Your ref
Our ref TL /3/2013/0271
Date 3rd May 2013

Planning application no: 3/2013/0271
Proposal: Erection of two detached dwellings.
Location: Land at George Lane Read Lancashire.

Client JWPC		
Job Title Proposed development to Land at George Street Read		
Drawing Title Proposed Site Plan		
Scale 1:200@A1	Date August 2013	Drawn J Bowden

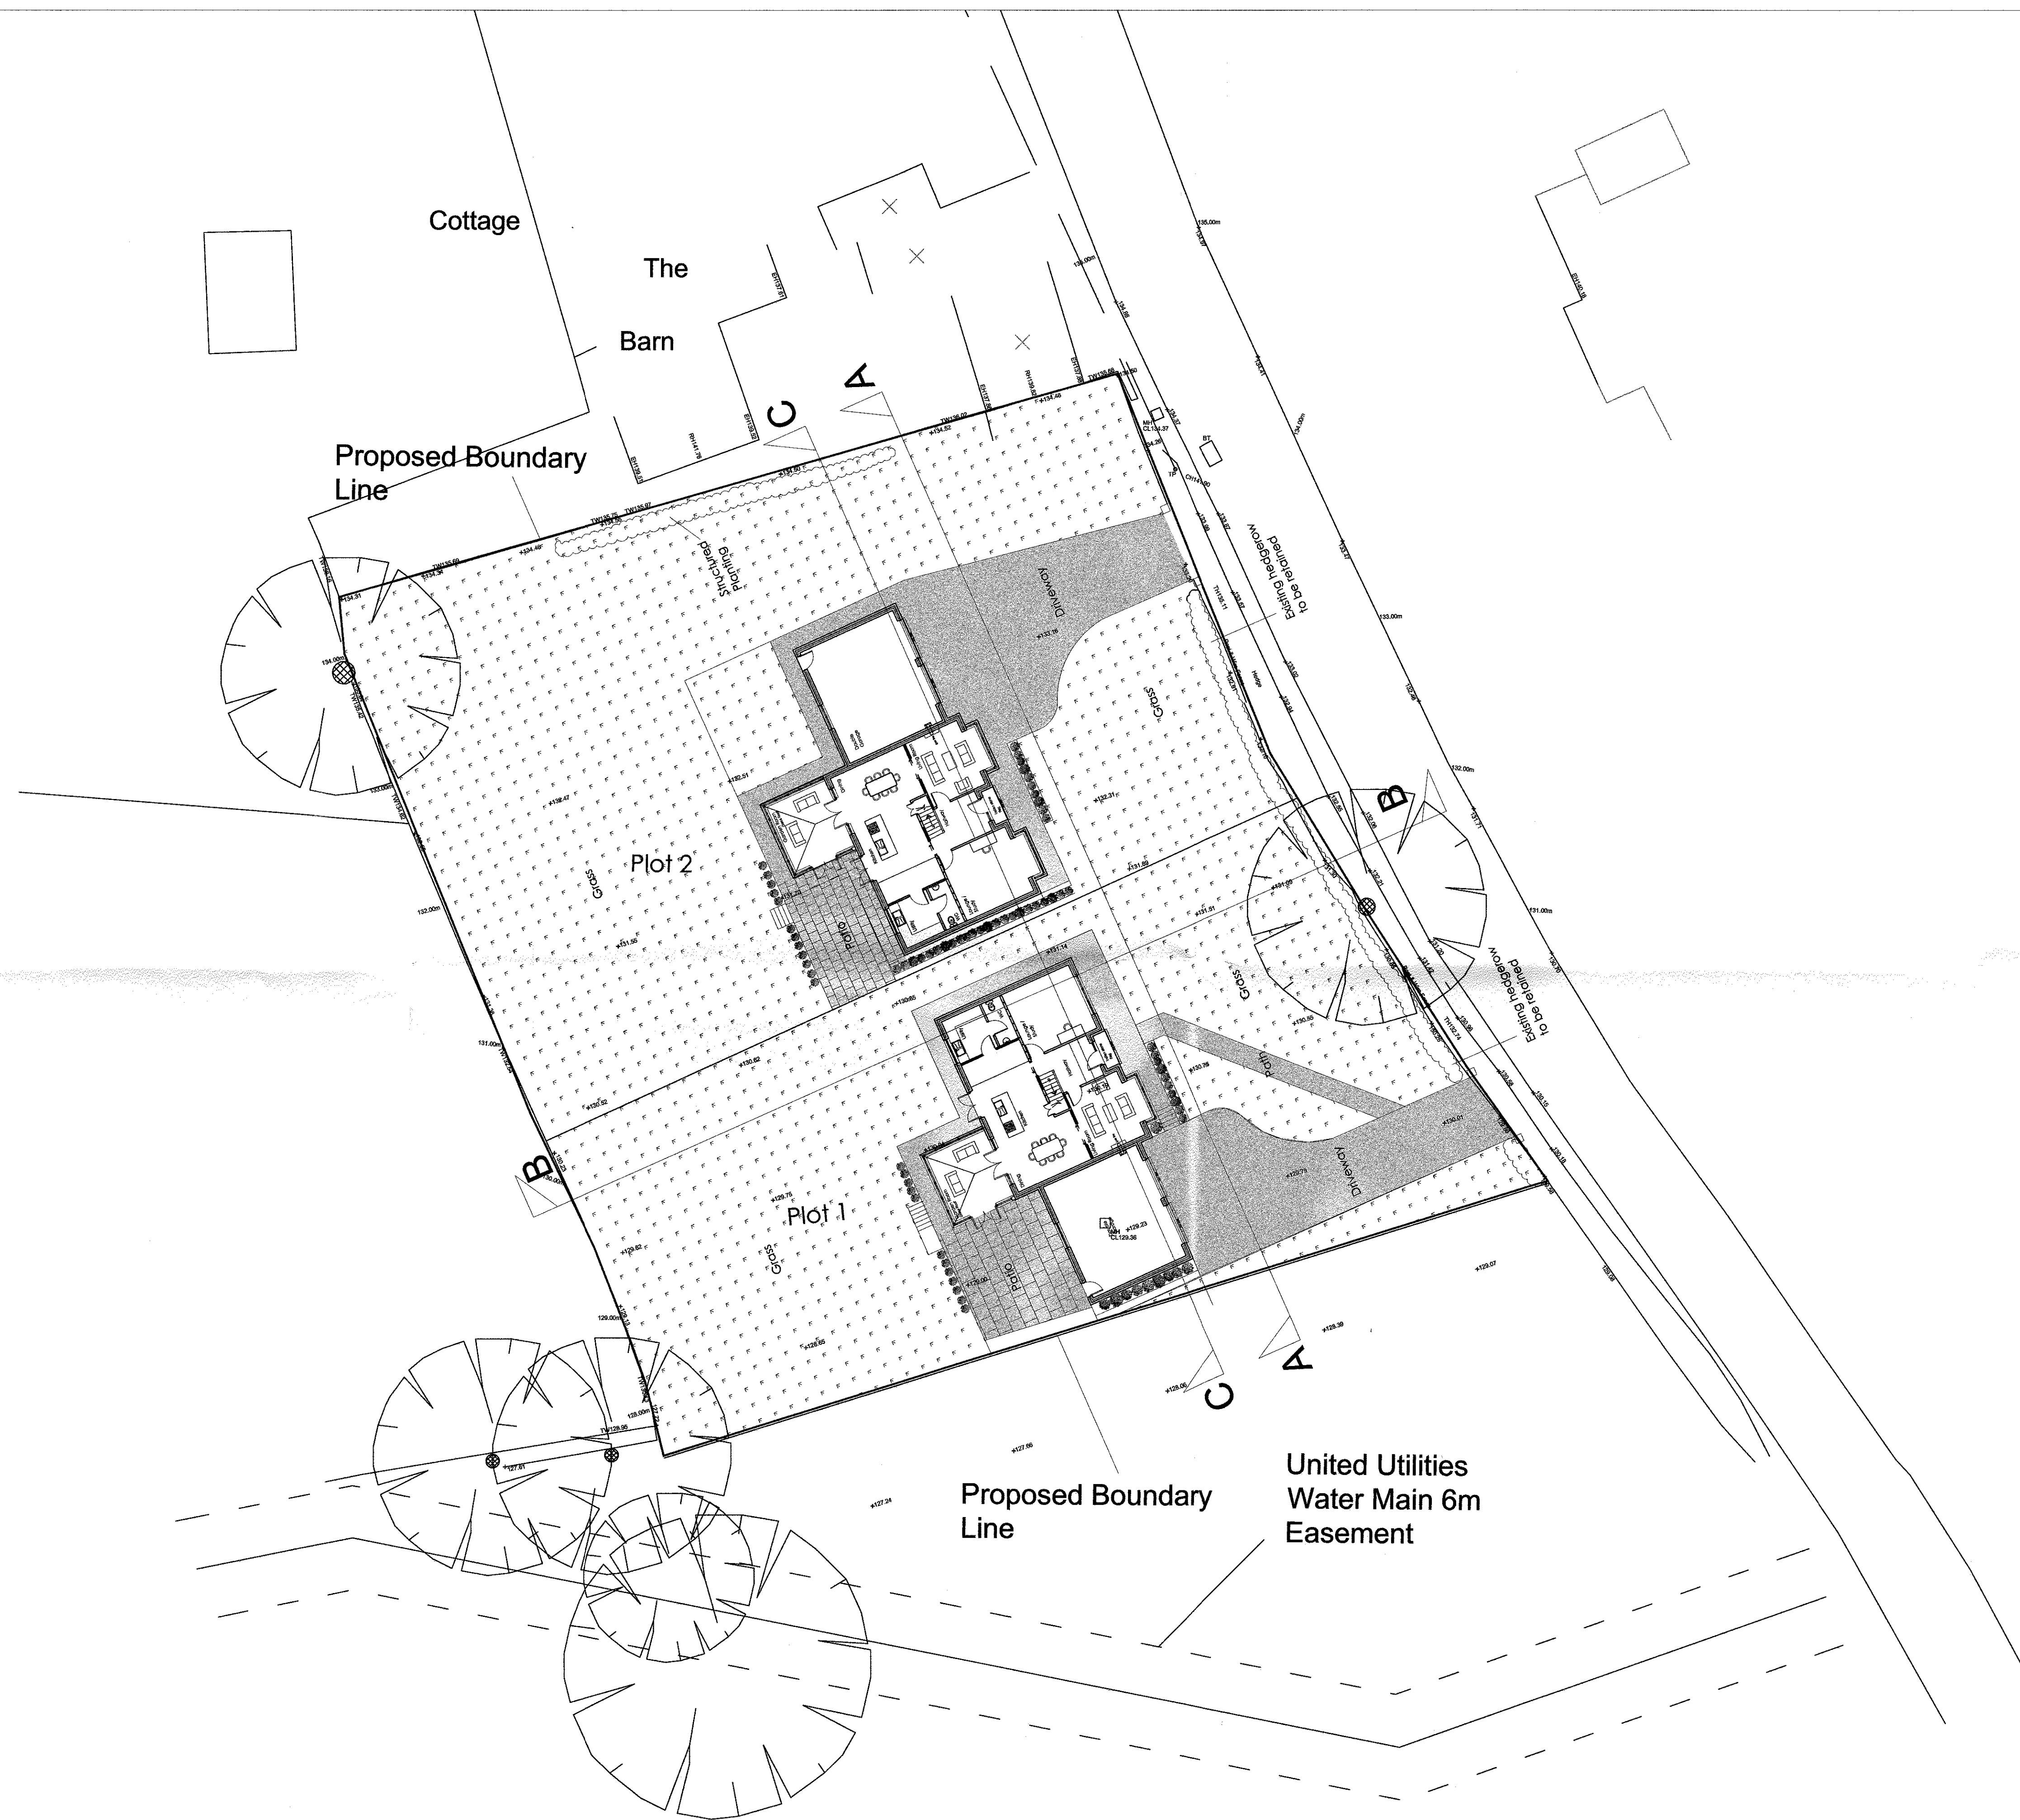
Works will be required in the highway to create the access to the site. The developer should contact LCC Highways to discuss these items and agree the works required.

For each dwelling, the visibility splays to be the subject of this condition shall be that land in front of a line drawn from a point 2.4m measured along the centre line of the proposed access from the continuation of the nearer edge of the carriageway of George Lane to a point measured 45m along the nearer edge of the carriageway of George Lane from the centre line of the access, and shall be constructed and maintained at footway/verge level in accordance with a scheme to be agreed by the Local Planning Authority in conjunction with the Highway Authority. Reason: To ensure adequate visibility at the street junction or site access.
